Please ask for: Ms Iqraa Malik
Email: iqraa.malik@terraquest.co.uk
Telephone: 0121 234 1390
Our Ref: A/218/21/HH
Your Ref:
Date: 13th October 2021

Application for Planning Permission for Works or Extension to a Dwelling

Development: Erection of part single, part two storey side extension, single storey rear extension and installation of front canopy
Location: 3 Ham Manor Farm Cottages West Drive Angmering BN16 4JF

Site Block Plan (1:500)

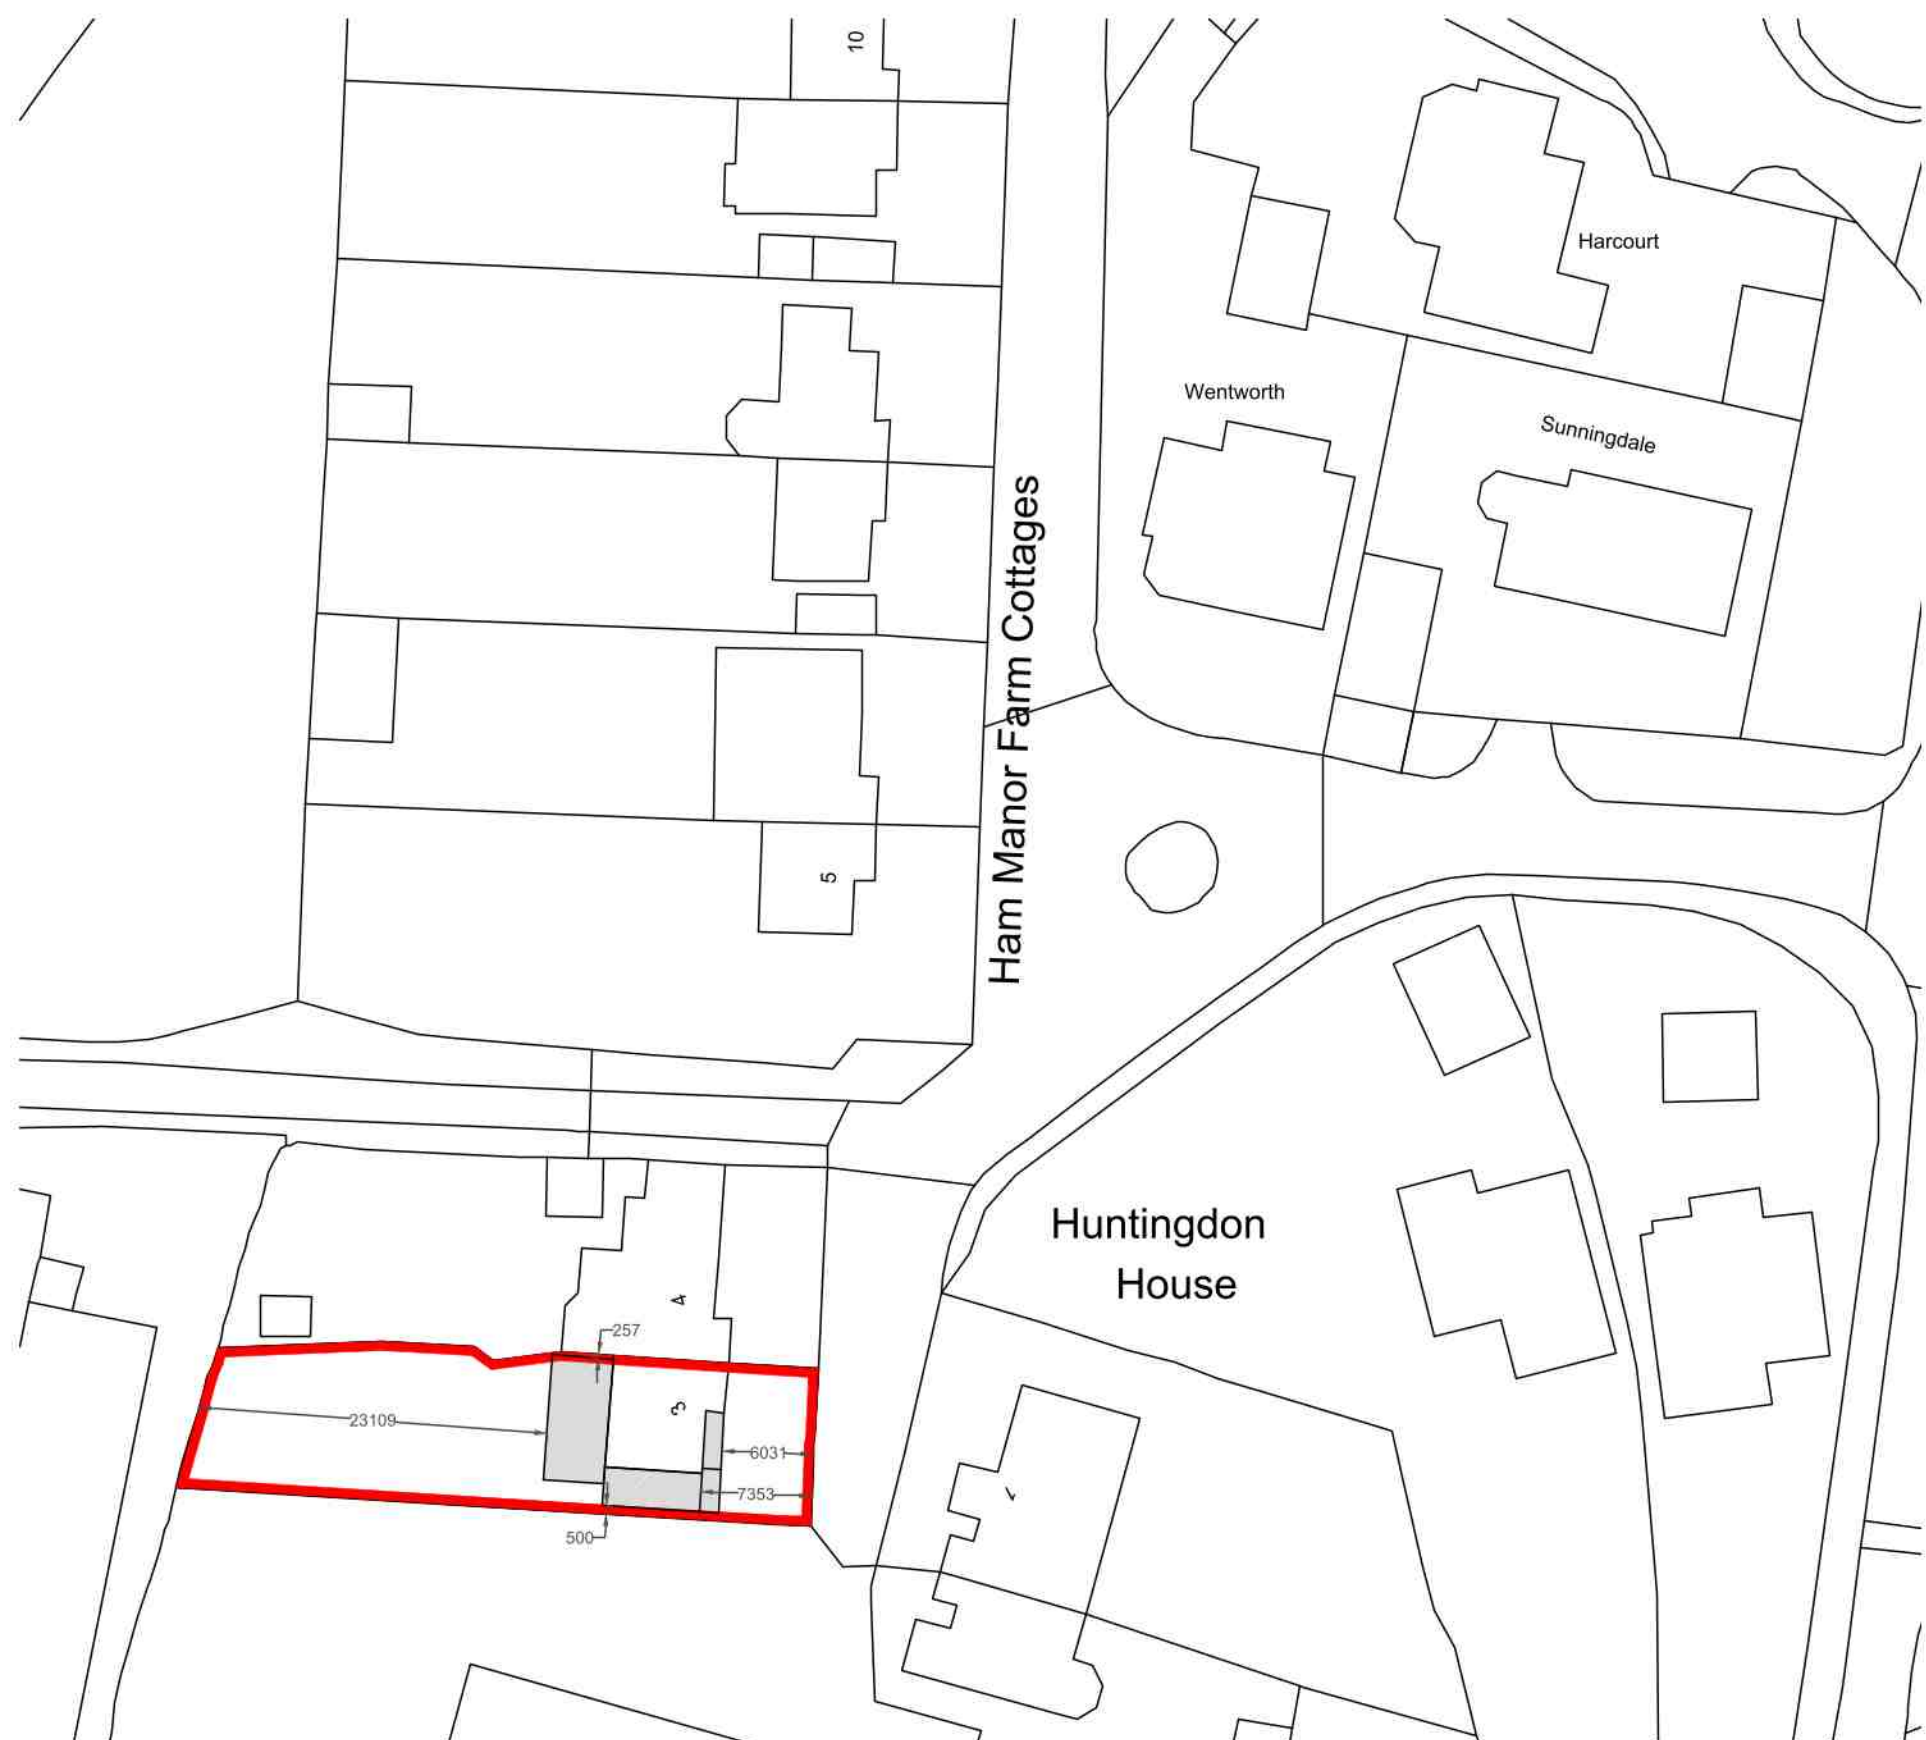
The scale for site location plan on drawing no. 1319.02.a is incorrect as this is measuring to 1:500 rather than 1:1250. Further details of what must be included on the plan can be found in the Validation Requirements List.
